Re: The proposed development known as Ballinlee Green Energy Limited, for 17 no. wind turbines, a permanent 110kv substation, grid connection and ancillary development. Located in Ballincurra, Ballingayrou, Ballinlee North & South, Ballinrea, Camas North & South, Carrigeen, Knockuregare and other townlands in County Limerick.

An Coimisiun Pleanala - Case Ref: PAX91.323780

We are writing to formally object to the above referenced planning application (Case ref. 323780).

Figure 15-3: Wind Turbine and Dwelling Locations

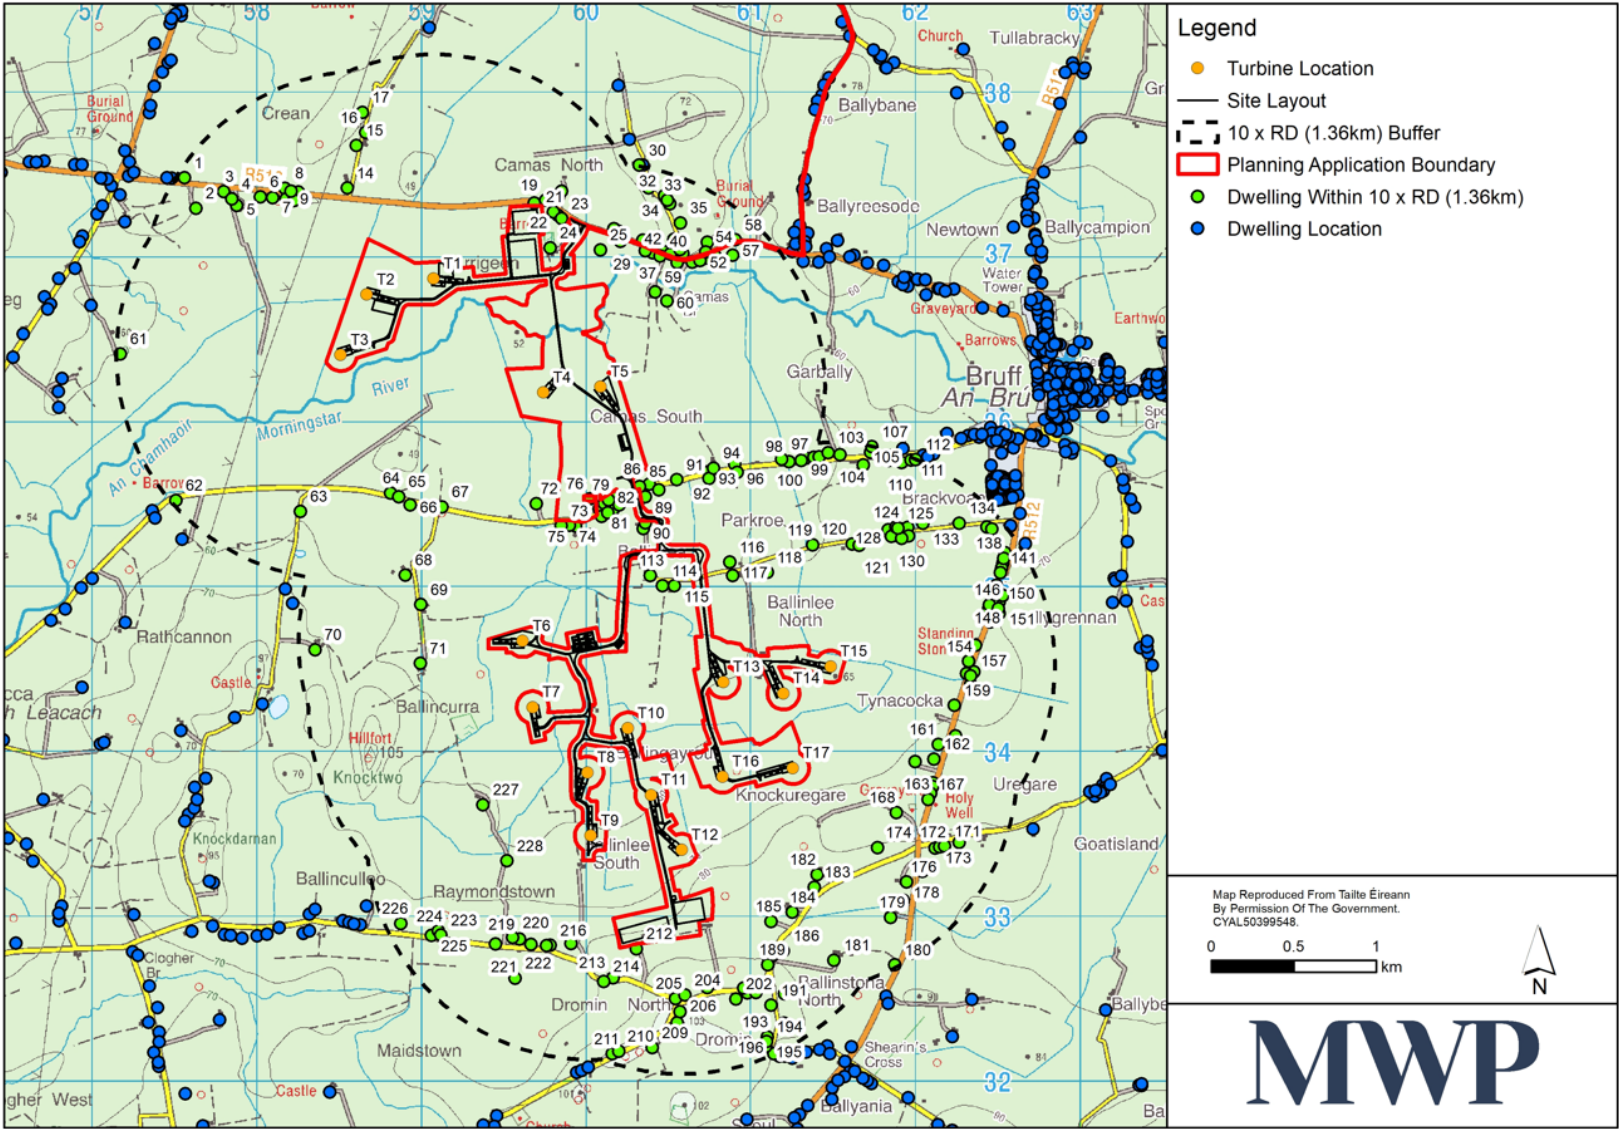
The Current 2006 WEDG (20 years old) recommend that shadow flicker at dwellings within 500m of a turbine should not exceed 30 hours per year. Many homes in this project exceed this, in the proposed plans our home is denoted by number "161" and nearly exceeds this recommendation.

It is very notable in many of the chapters in their EIAR that Ballinlee Green Energy suggests that Bruff is 3kms away from the site, in the EIAR Chapter 15 Shadow Flicker Figure 15-3 they assess all dwellings (best practice 1.36km) approximately 20 of these homes assessed are within the town of Bruff.

Why can Ballinlee Green Energy Limited state this project is 3kms from Bruff? This is incorrectly stated, this area is not an isolated rural site, Bruff has a growing population the proposed wind farm is adjacent to the town, not in a remote rural location.

Figure 17-4: Gas Network Ireland Maps (Southern Section of Wind Farm Boundary)

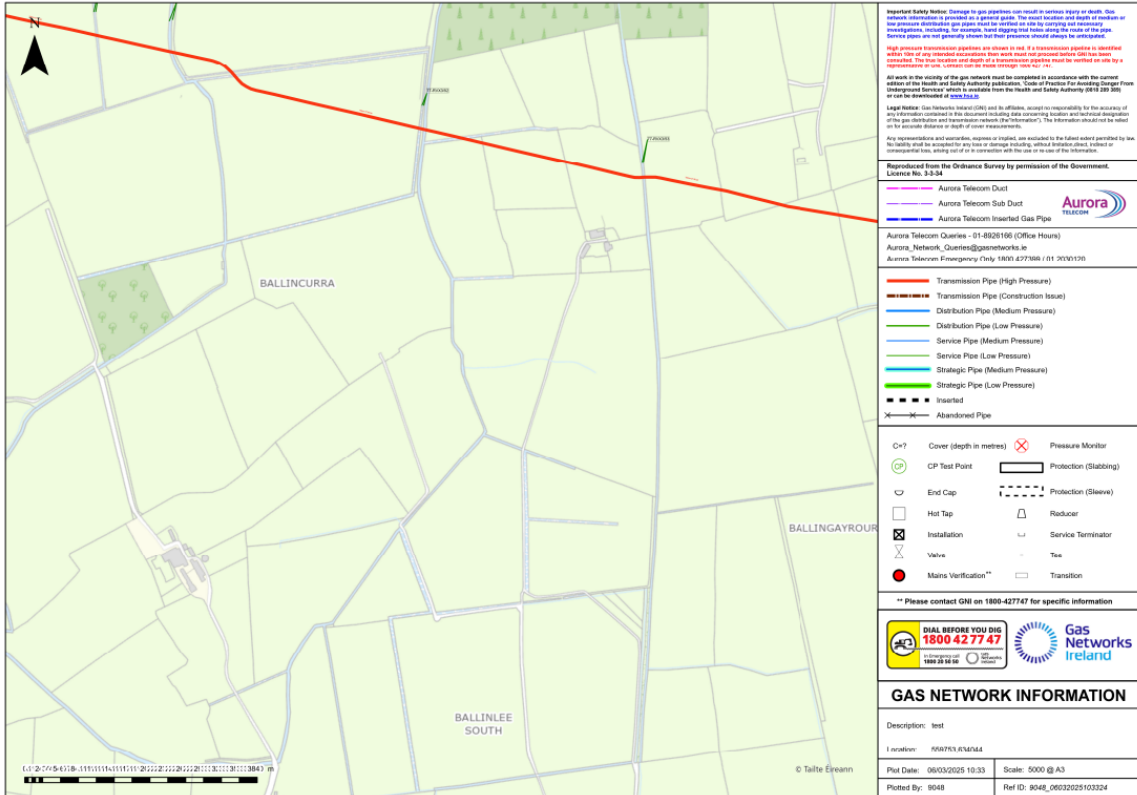
The Gas Transmission (High Pressure) Pipeline passes through our land folio and passes through the adjacent lands through the proposed wind farm site. We have failed to see in the project plan; What if scenario- if a blasting error / disaster occurred what measures of safety would be implemented, what access routes to the site would be taken by the fire brigades, a disaster like this could cause deadly consequences for the wider community of Bruff town. These are legitimate concerns regarding fire tender access and the adequacy of emergency response routes, which is not clearly demonstrated in the application. We believe this project (Case 323780) should be refused.

Figure 17-10: Plan view of Radio links that cross through/near the proposed wind farm development

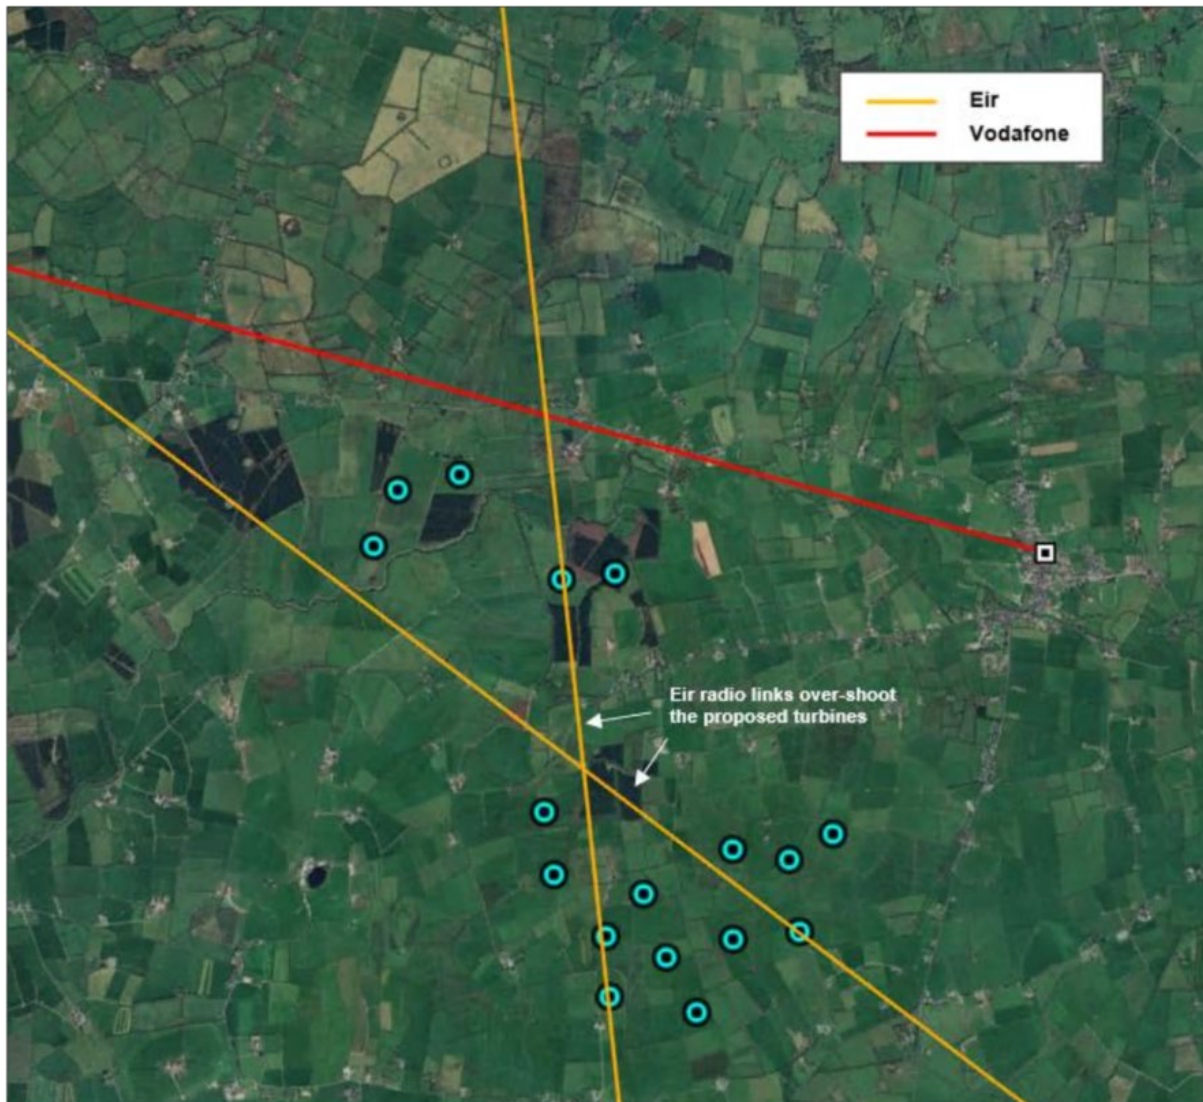
Proper clearance from T17 to the Fresnal Zone of the Slieveragh to Toureen radio link will disrupt my internet connections for my home and this will cause my working from home options difficult.
